Appeal Decision

Appeal Ref: APP/Z4718/D/24/3343749

2 Four Winds, Highbridge Lane, Skelmanthorpe, Kirklees, Huddersfield HD8 9JY

- The appeal is made under section 78 of the Town and Country Planning Act 1990 against a refusal to grant planning permission.
 - The appeal is made by Mr & Mrs N Hepworth against the decision of Kirklees Council.
 - The application reference is 2023/62/93664/E.
 - The development proposed is for the erection of extensions and alterations (modified proposal).
-

title GA as Existing - showing fallback position
number 22014D-05-P01
scale 1:100
size A1

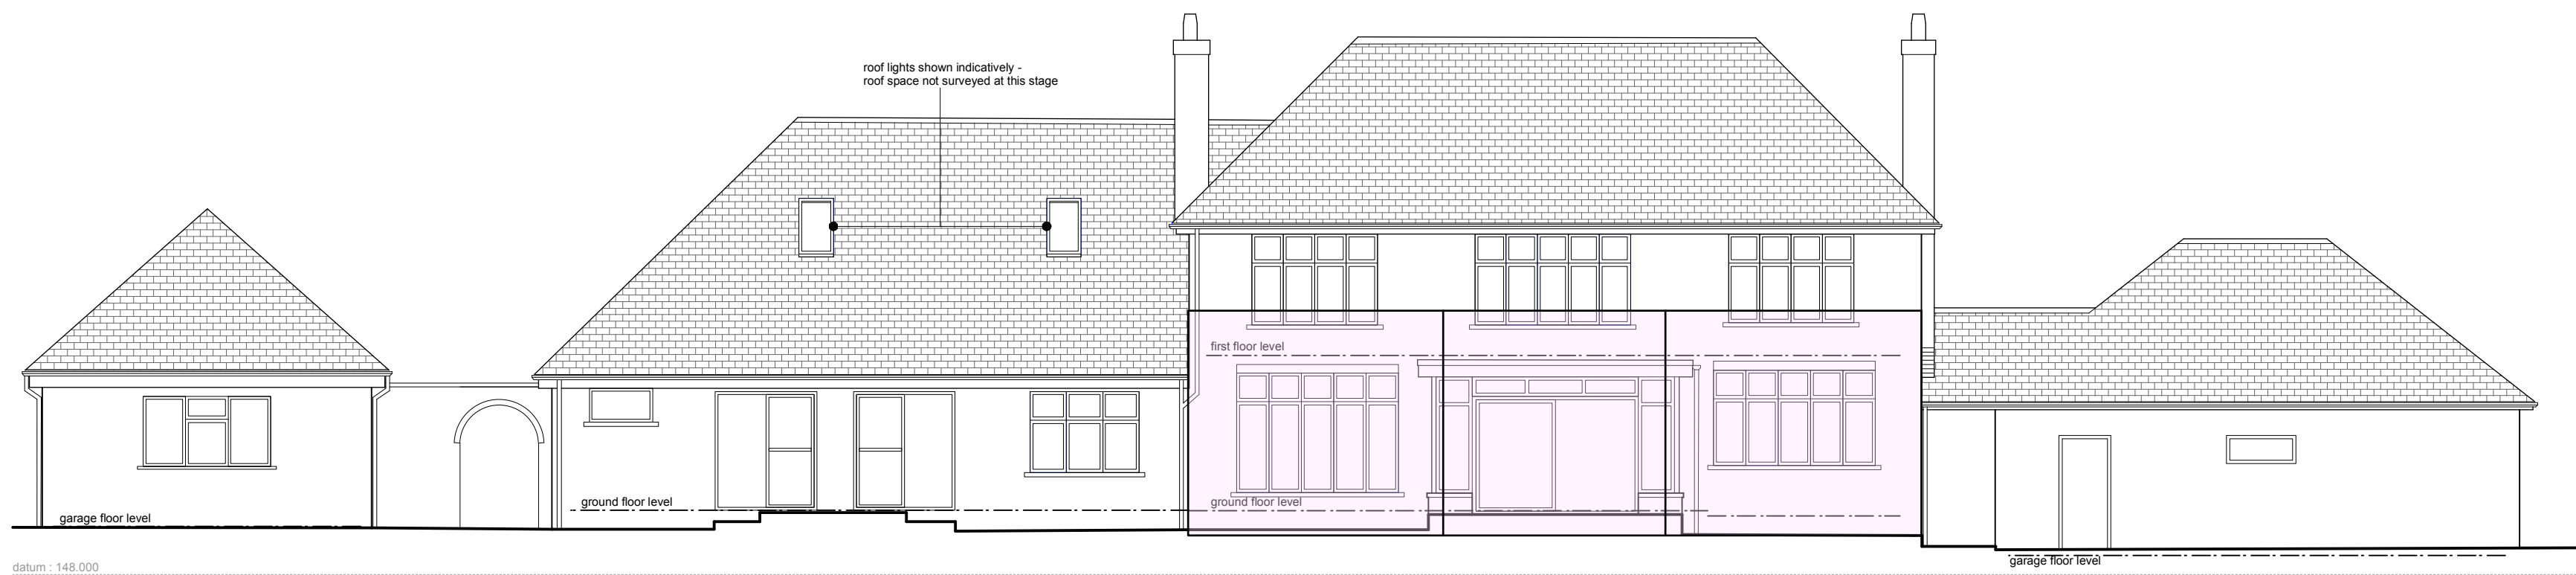
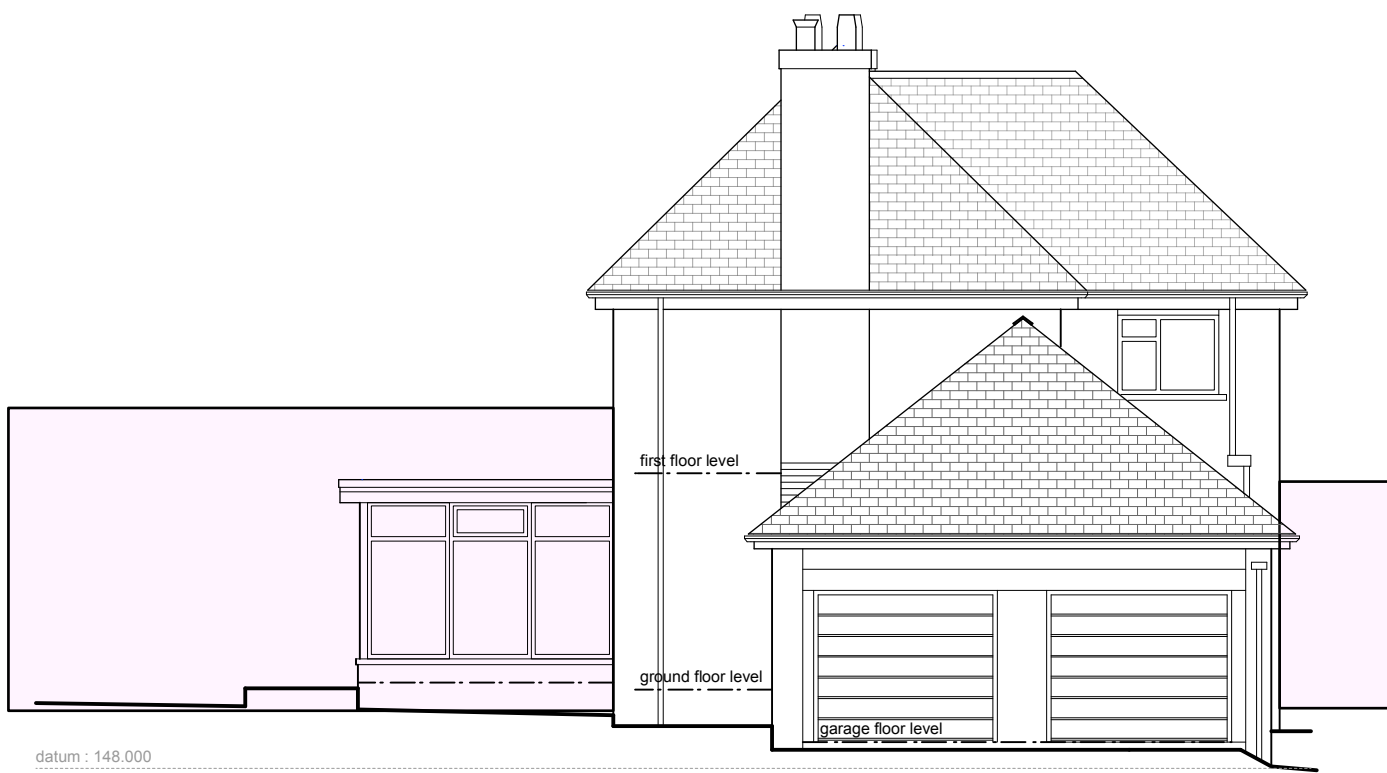
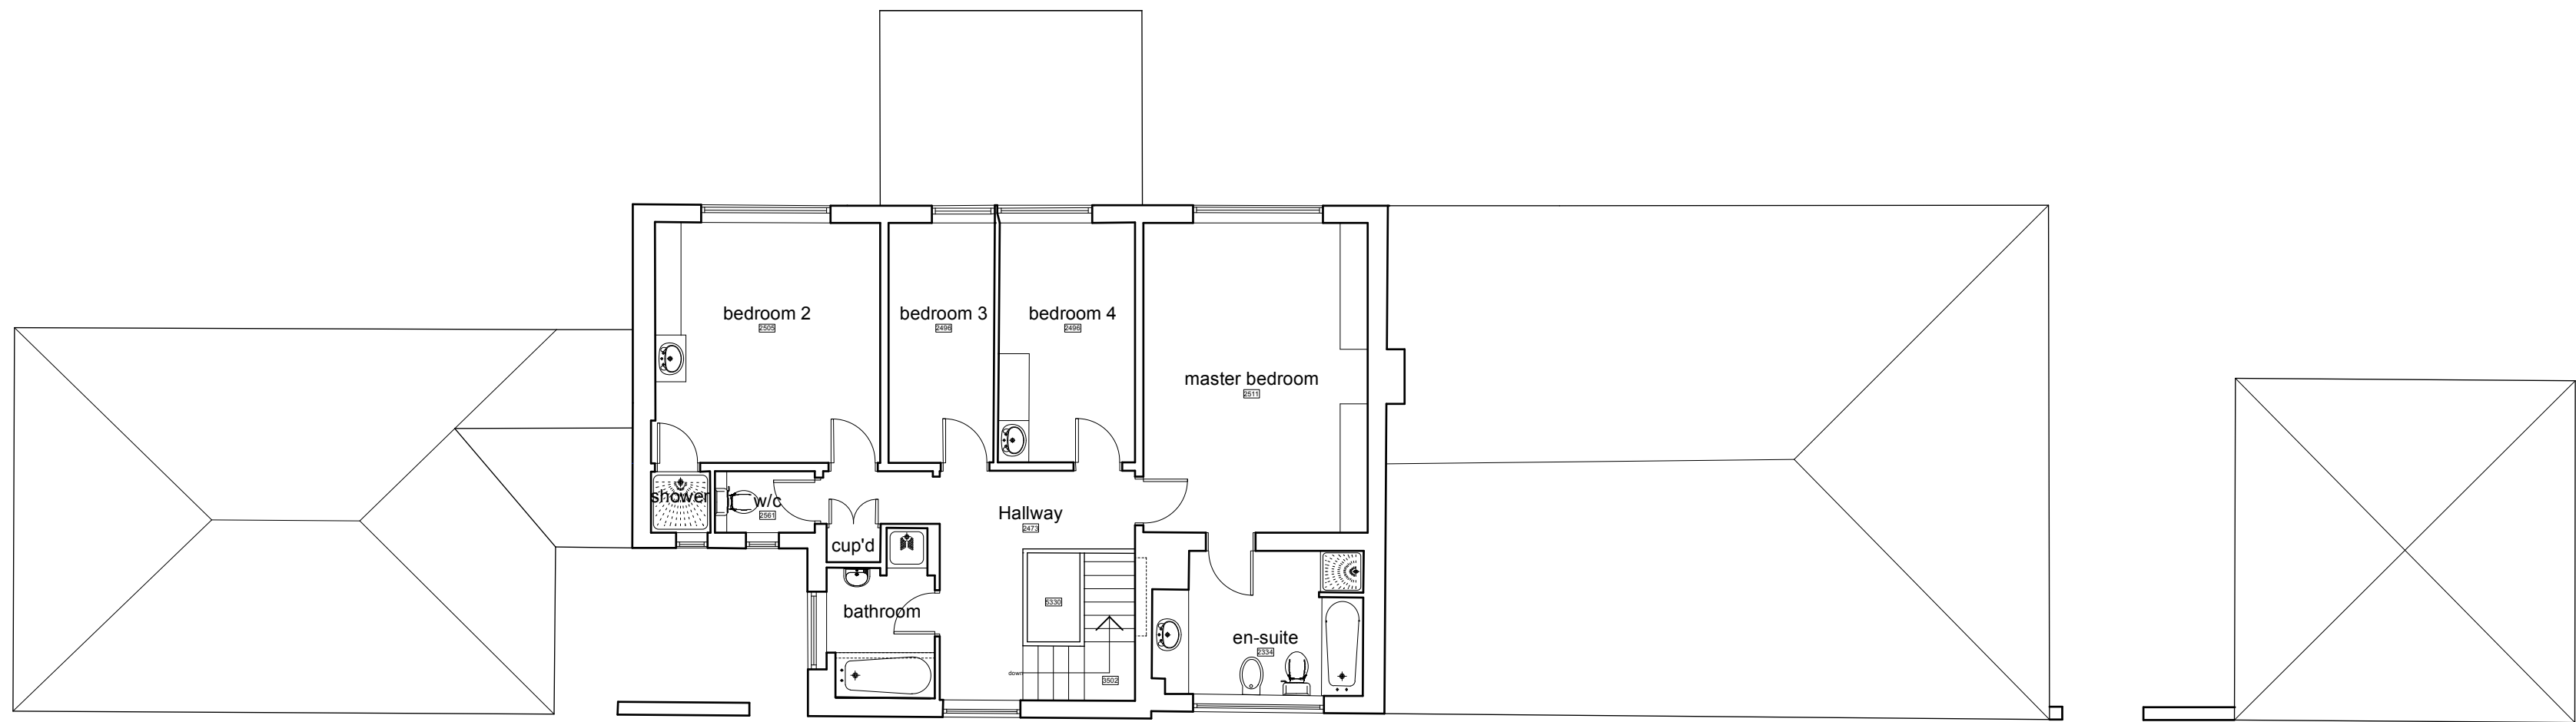
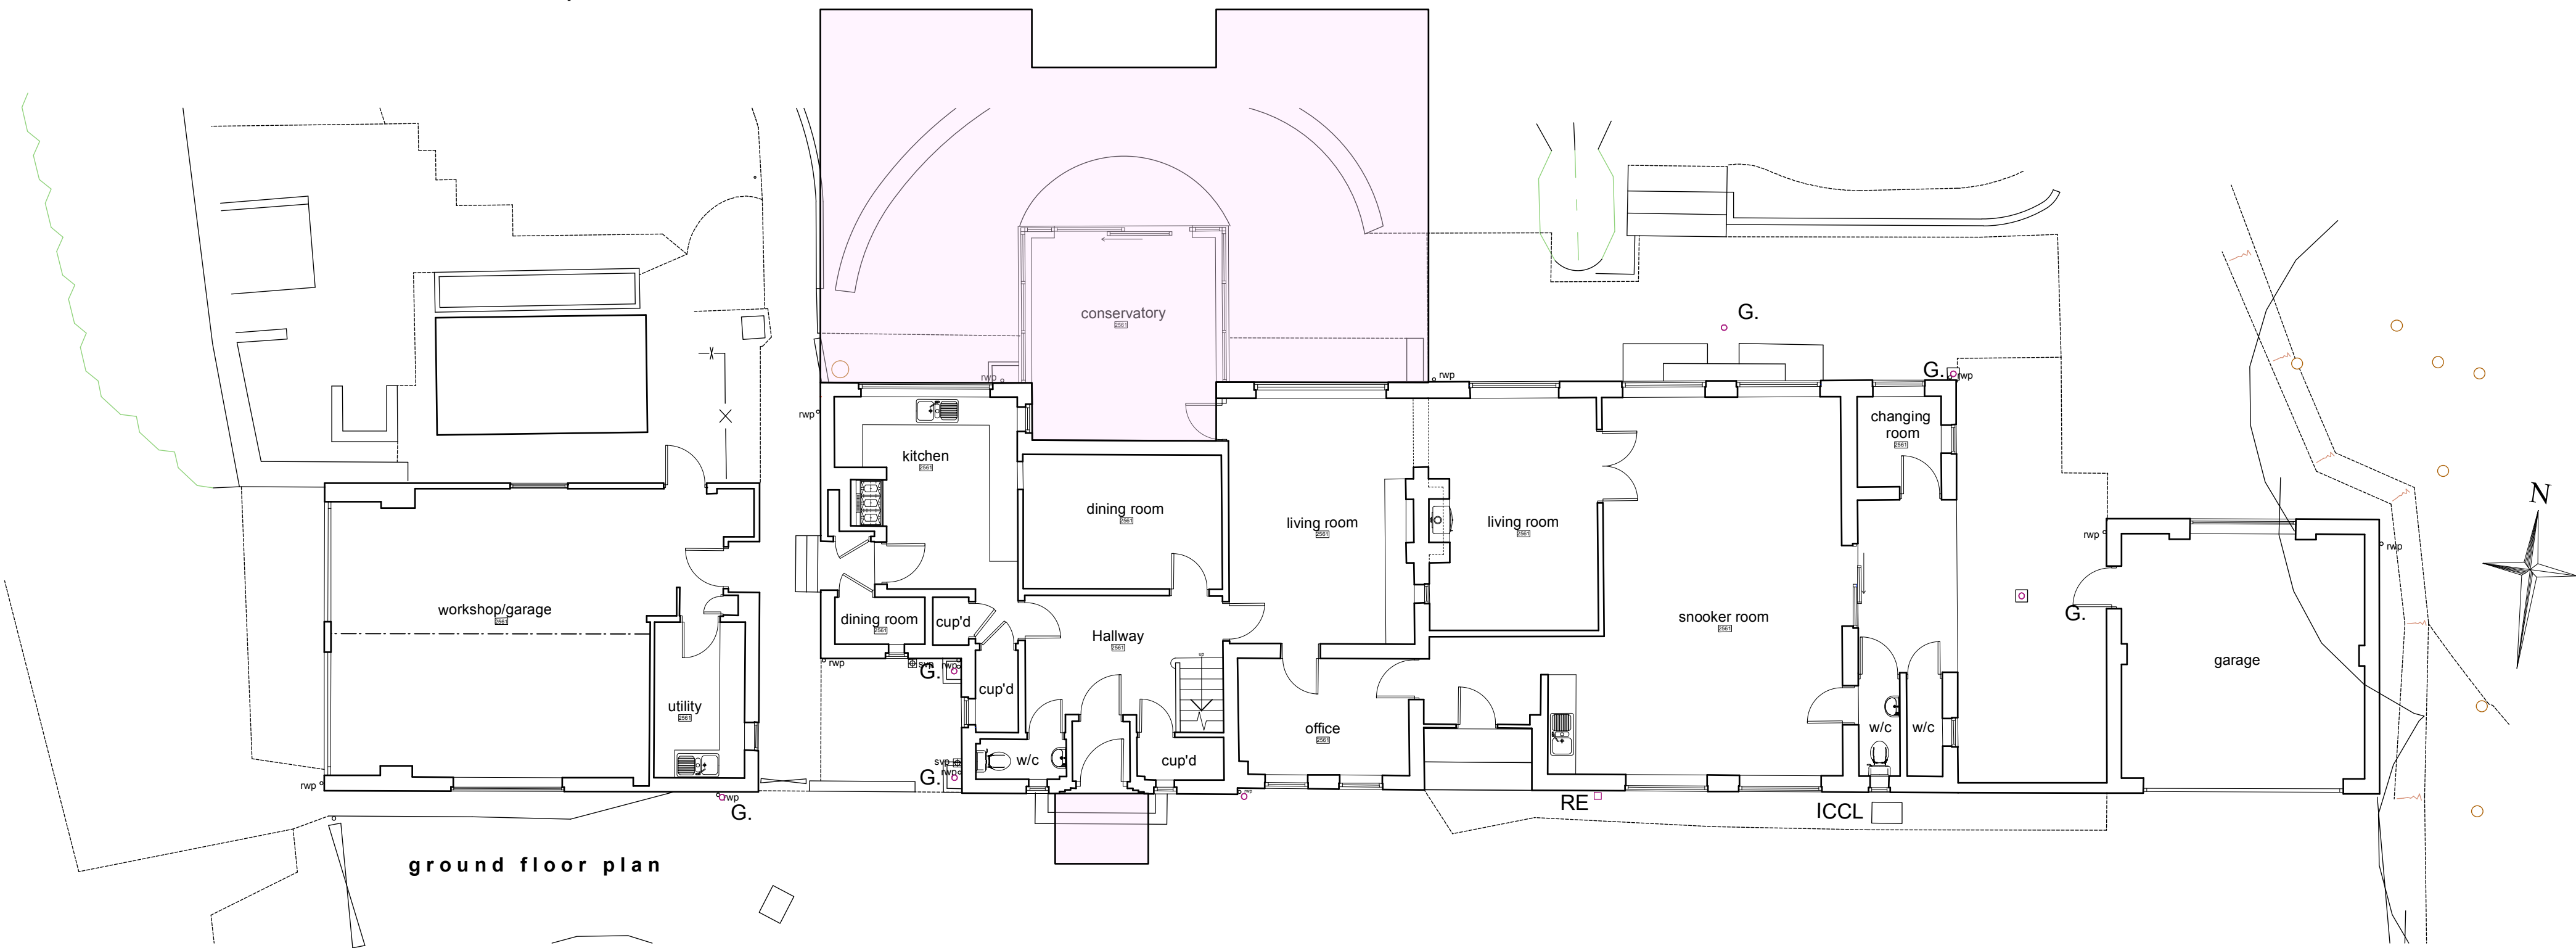
15. The Justification Statement includes a plan that shows what could be built under permitted development rights (GA as Existing – showing fallback position 22014D-05-P01). The appellants indicate that, under these rights, if permitted development extensions were maximised, the overall volume of the dwelling would be 2,080 cubic metres. The proposal would result in a total volume for the altered dwelling of approximately 2,065 cubic metres. However, the degree of weight to be given to the fallback position depends on whether or not the fallback position would be equally or more harmful than the scheme proposed.

16. The fallback position differs from the appeal proposal in that the form of the development in that case would be restricted to single storey elements. The extensions proposed in the fallback position would appear more subordinate to the host dwelling, particularly because of their form and massing in relation to the original dwelling. Consequently, the appeal proposal would cause greater harm to the openness of the Green Belt and to the character and appearance of the dwelling than the fallback position, which therefore carries limited weight in support of the appeal development.
